**39 Oak Avenue  
Ickenham  
UB10 8LR**

## **PLANNING STATEMENT**

*Erection of a replacement dwellinghouse*

- 1.1 This application follows a recent pre-application submission (LPA ref: 321/PRC/2021/186) in which the council gave their feedback in a letter of 18<sup>th</sup> October 2021.

SIDE ELEVATIONS (2/2)

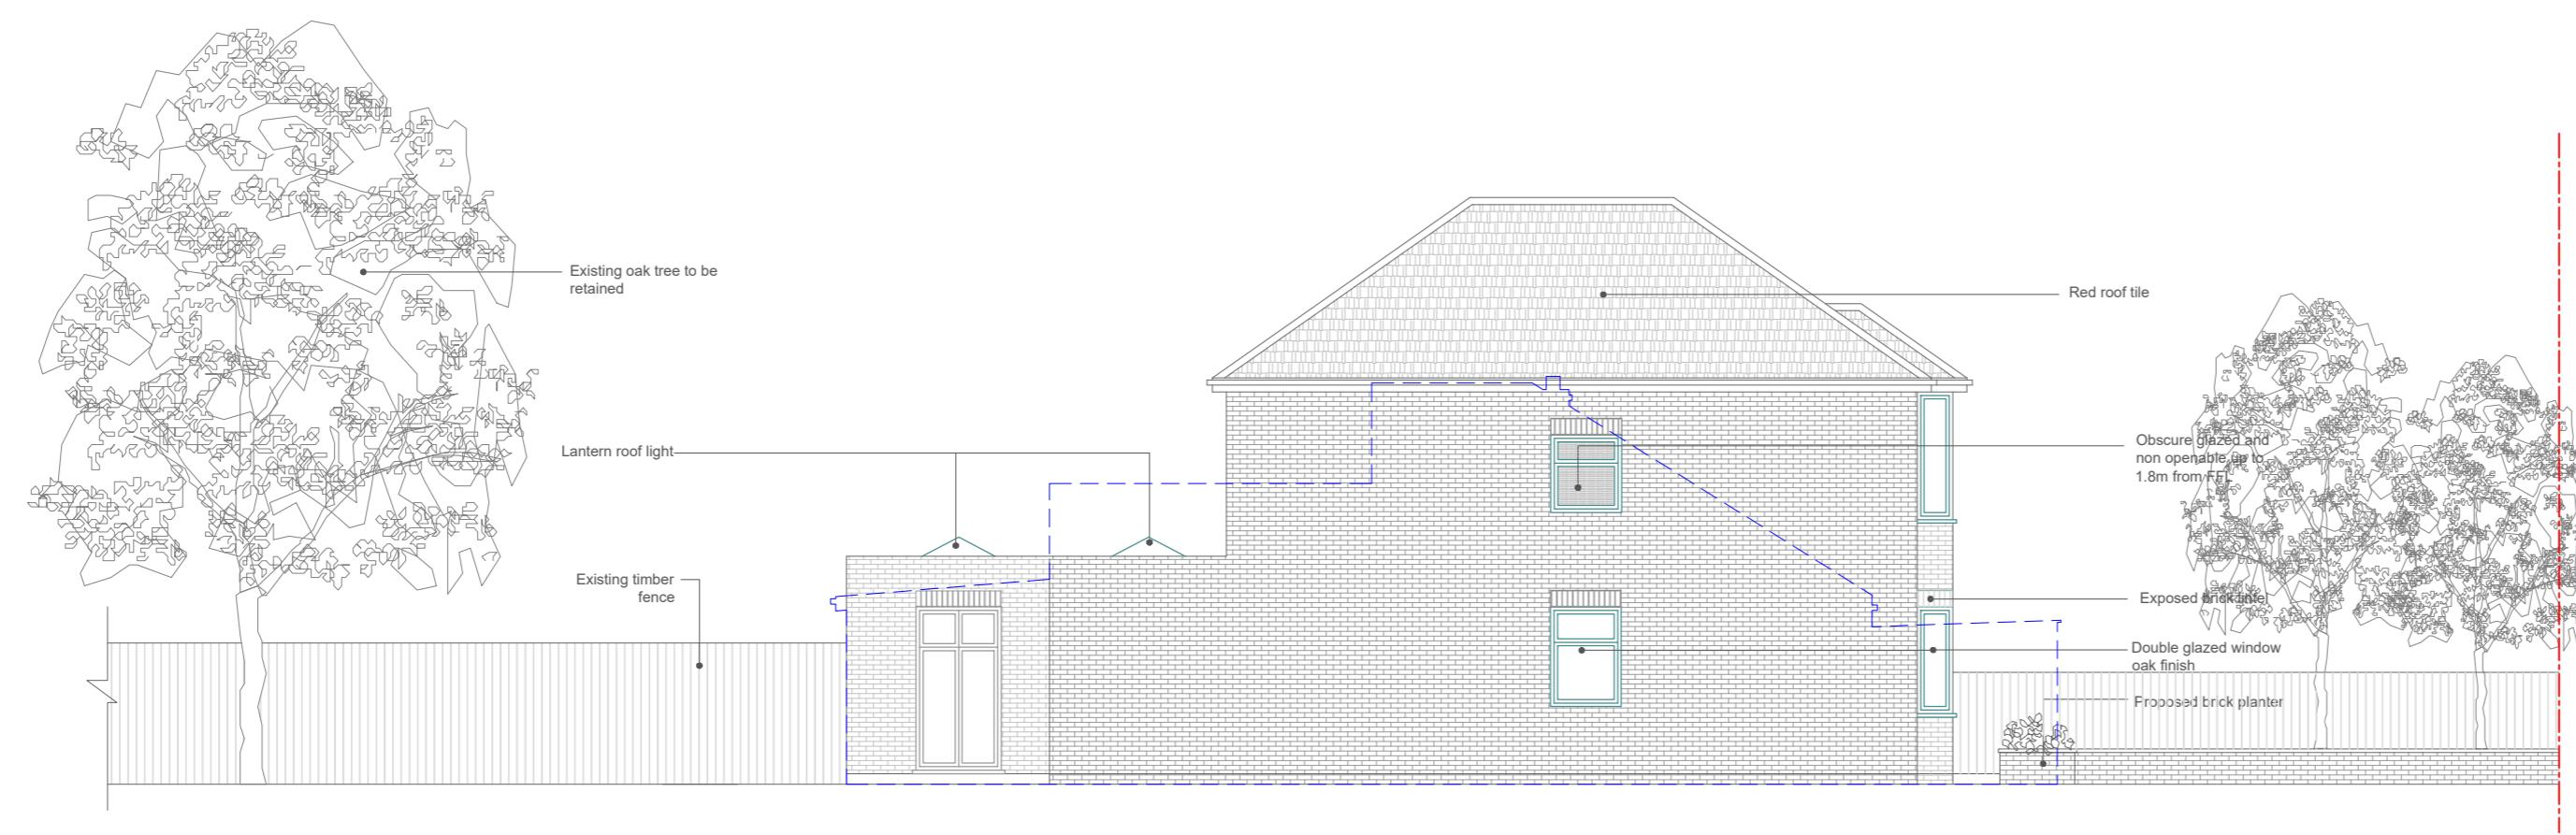
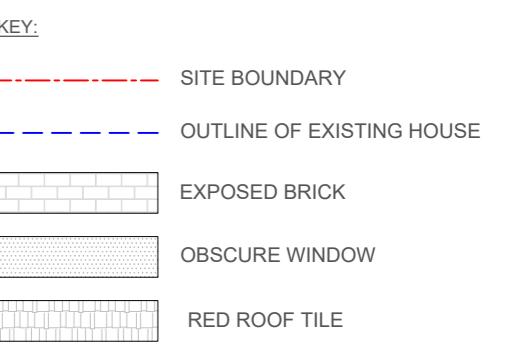
3.21 The final request from the planners in relation to residential amenity was that the side elevations demonstrate that the ground floor and first floor bathroom windows be obscure glazed and non-opening up to 1.8 metres above finished floor level and this annotation has now been added to the proposed drawings.
